**EMBREY BUILDERS, LLC.**

**RFI**

**RFI #: 107**  
**Date:** 4/9/2012  
**Job:** EB-02 Keller Springs Lofts  
**Phone:** 877-777-5115

**Subject:** Structural/Architectural Difference at Courtyard Entry

**1 BUILDING FORMING PLAN**  
SCALE: 1:20

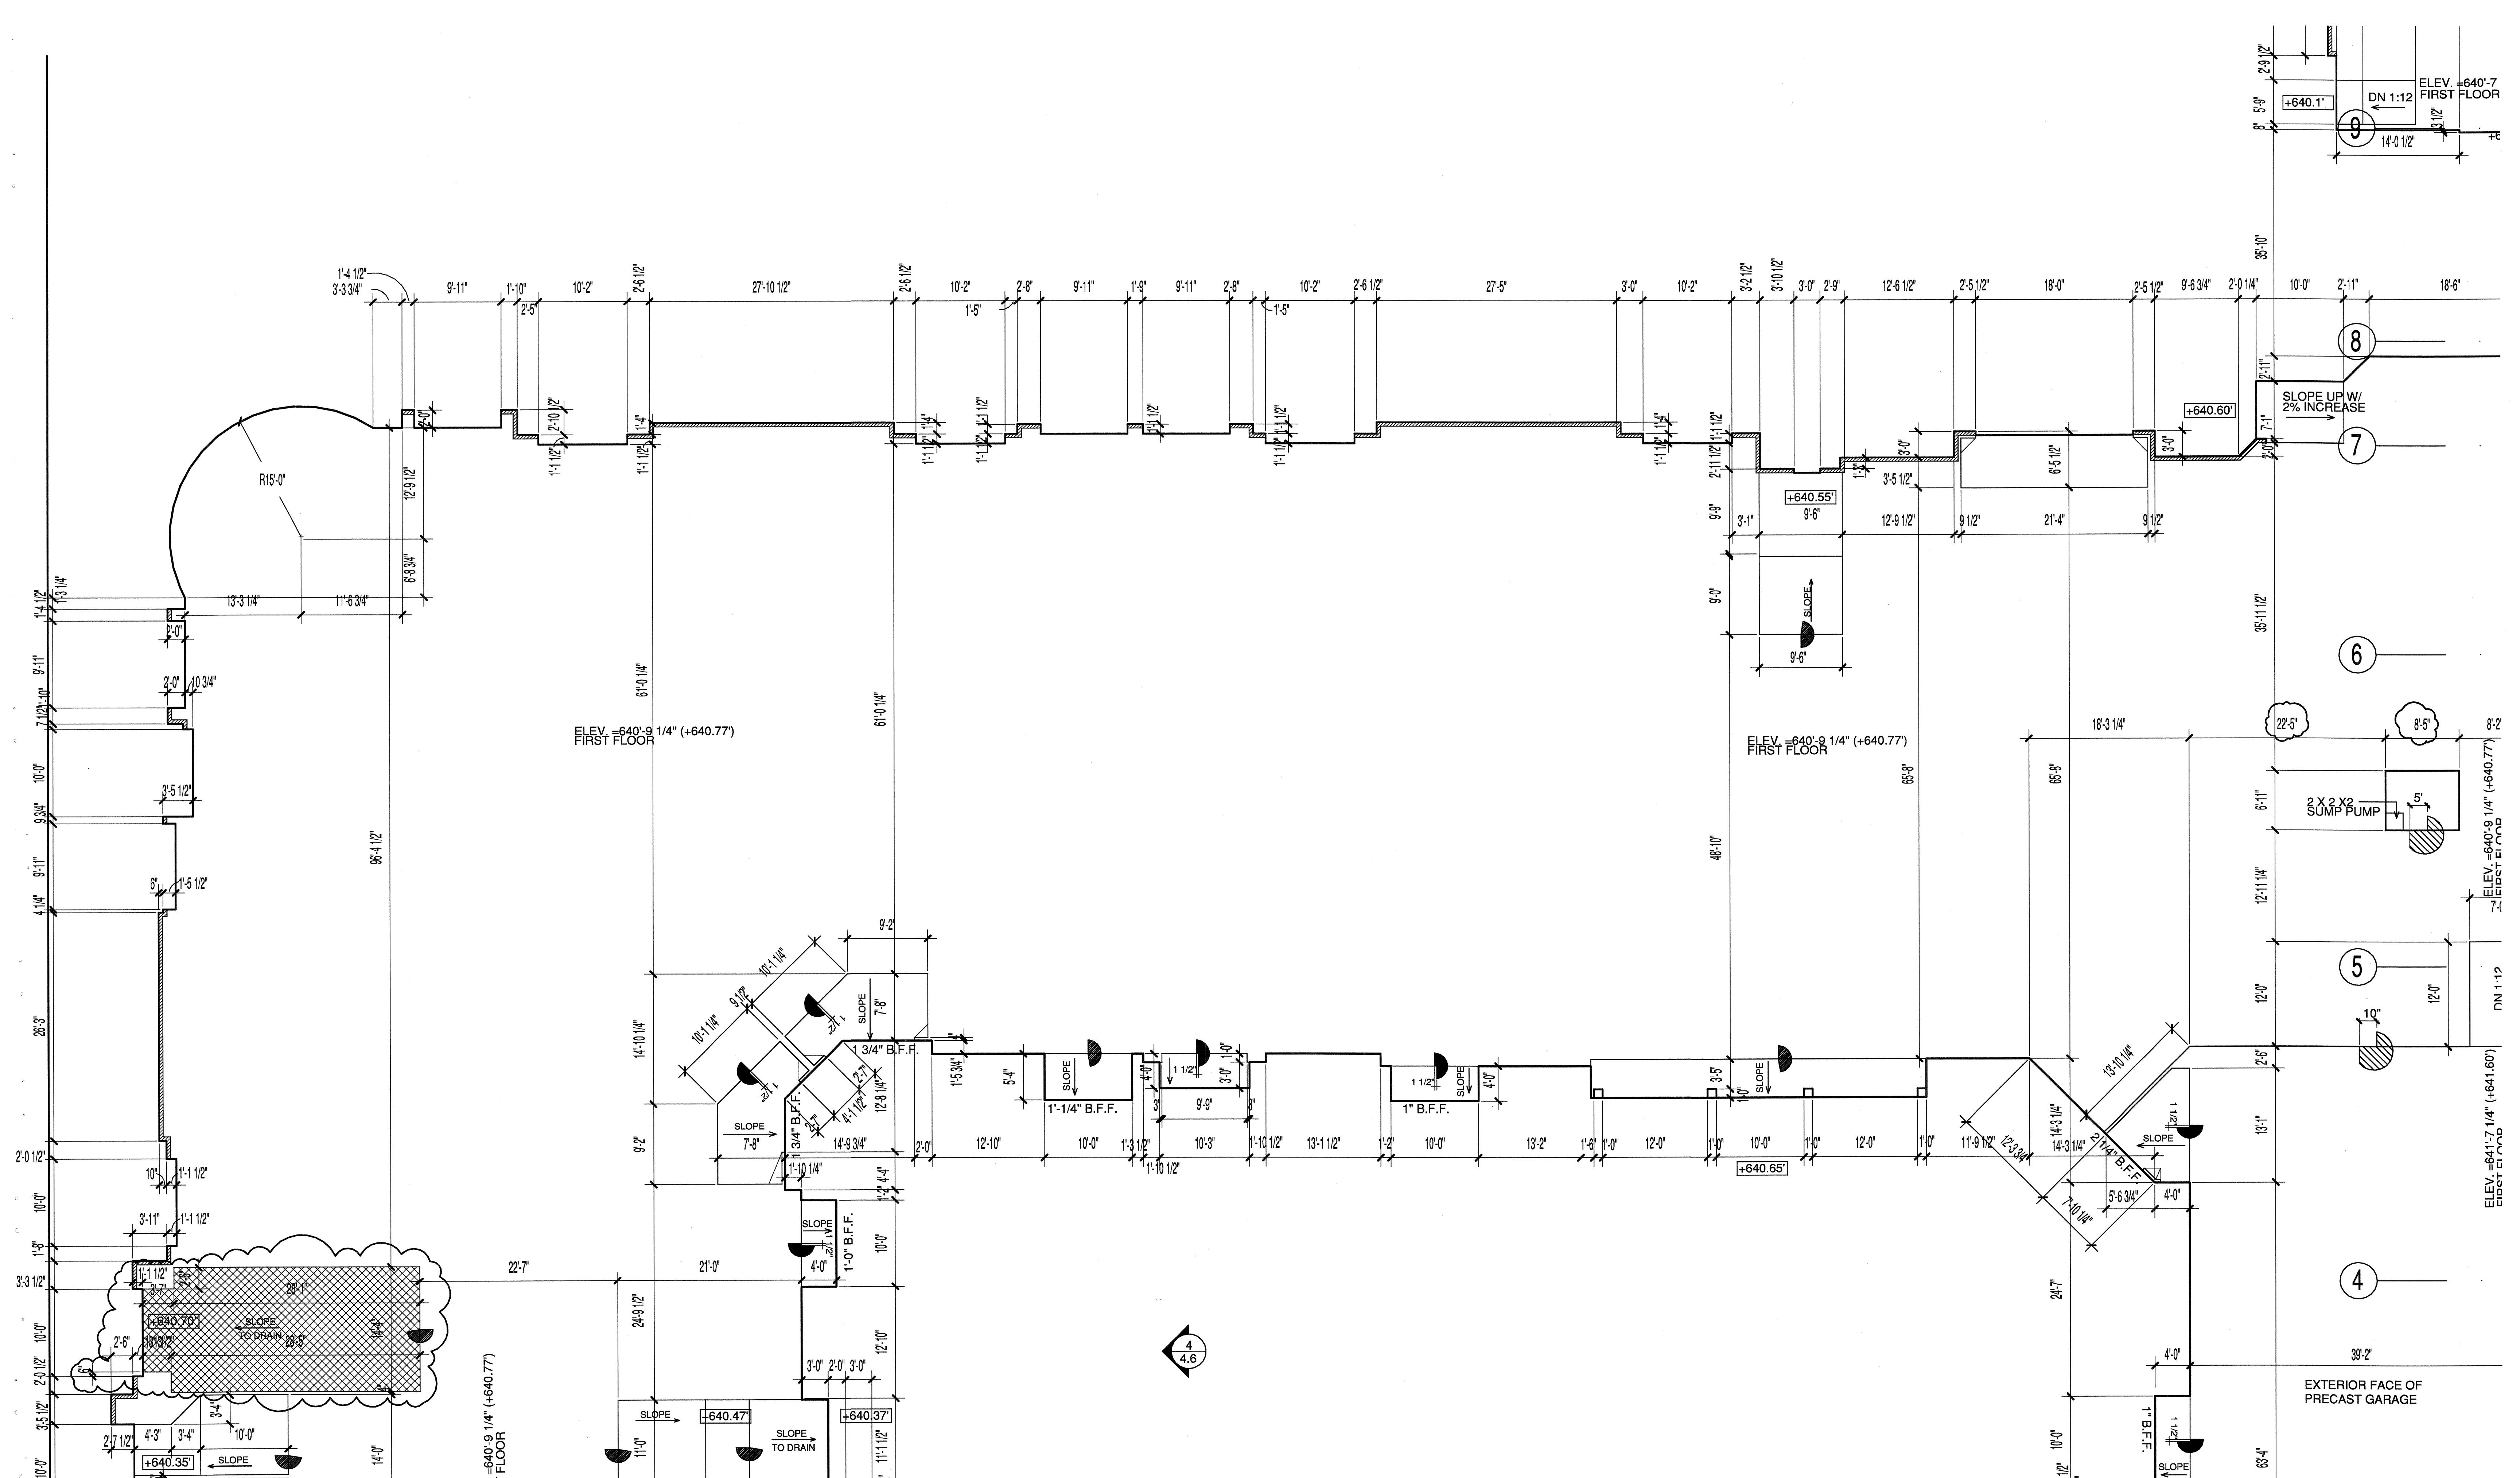
**Request:** S2.15 shows sloping concrete on the interior of the building entry from the courtyard. A3.1E does not show that. It only shows slope outside the door. S2.12 shows a slope down and then flat at the door. A3.1B does not show a slope. Please confirm which is correct for these two. **Date Required:** 4/17/2012

Structural plans are in agreement with Architectural Forming plans. Architect to confirm that this information is the design intent.

Trent is correct, and Yes, this is the design intent.

Performance Mechanical Pour 12,14,16,18

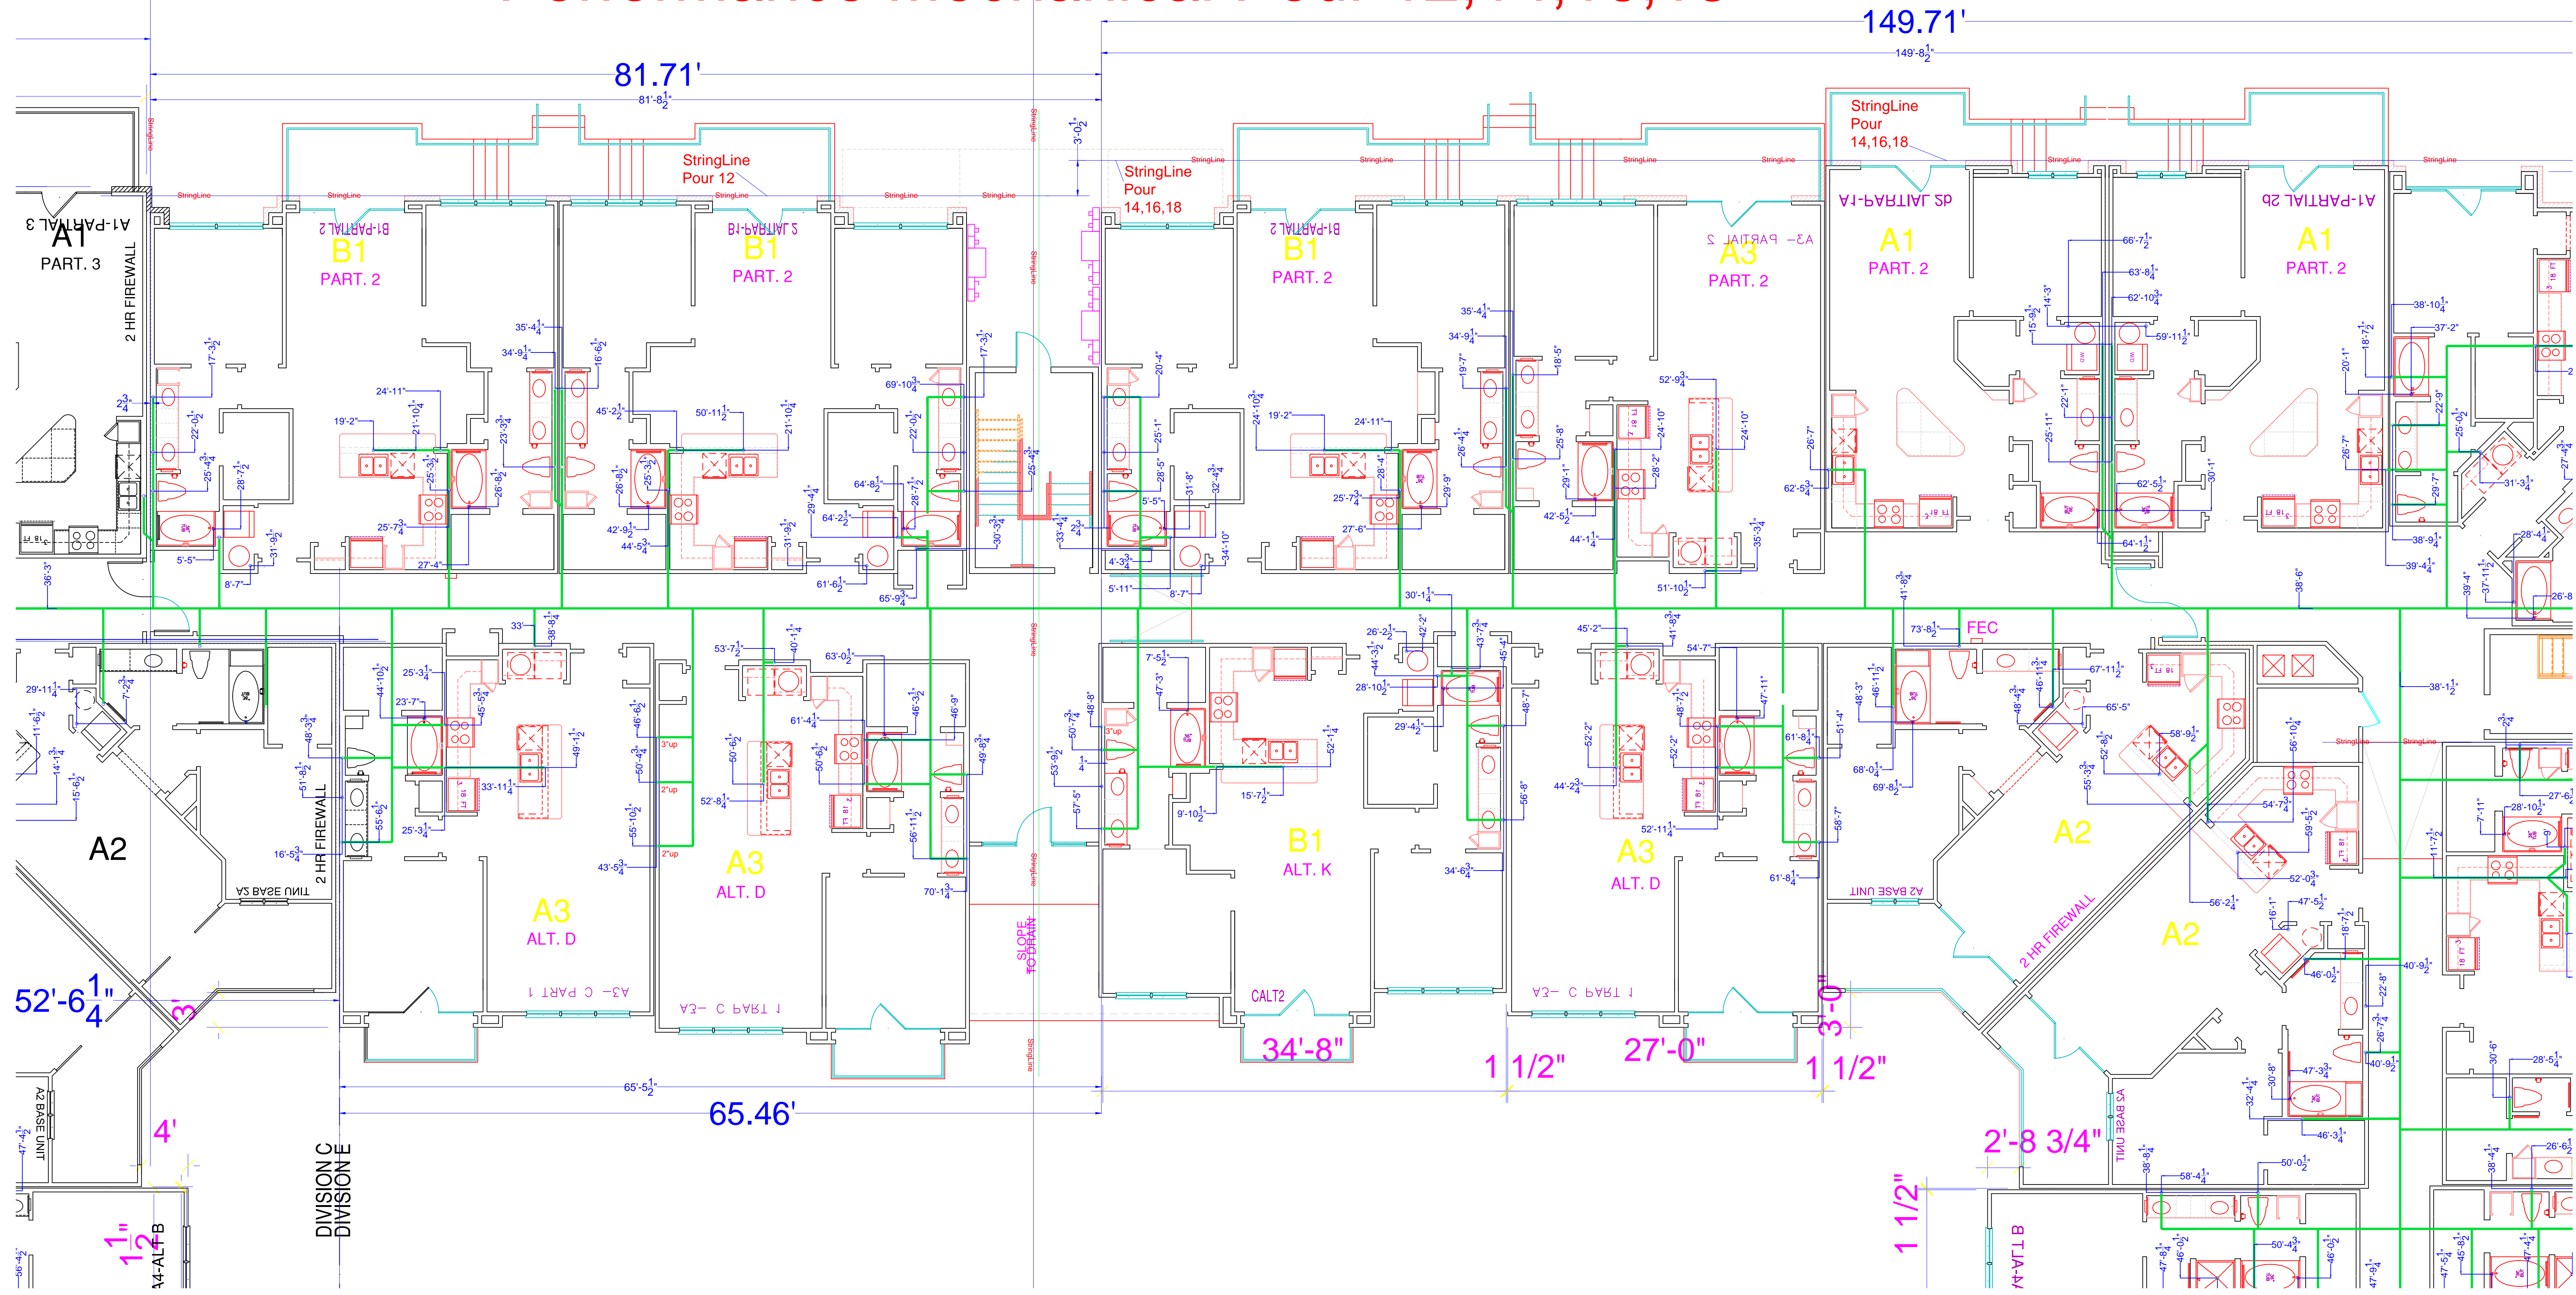
**Request:** At the Southeast corner of Pour #12 there is a corridor into the building that is sloped to the outside. The plans do not call for the piers or the beam to be lower at that area. This will cause the slab to be less than 10". Brande Parkey was on-site 6/4/12 for this grade beam inspection and directed us to leave out this section until a solution was decided. Please advise. **Date Required:** 6/21/2012

Please reduce depth of grade beam at this slab area to maintain 10" thick slab.
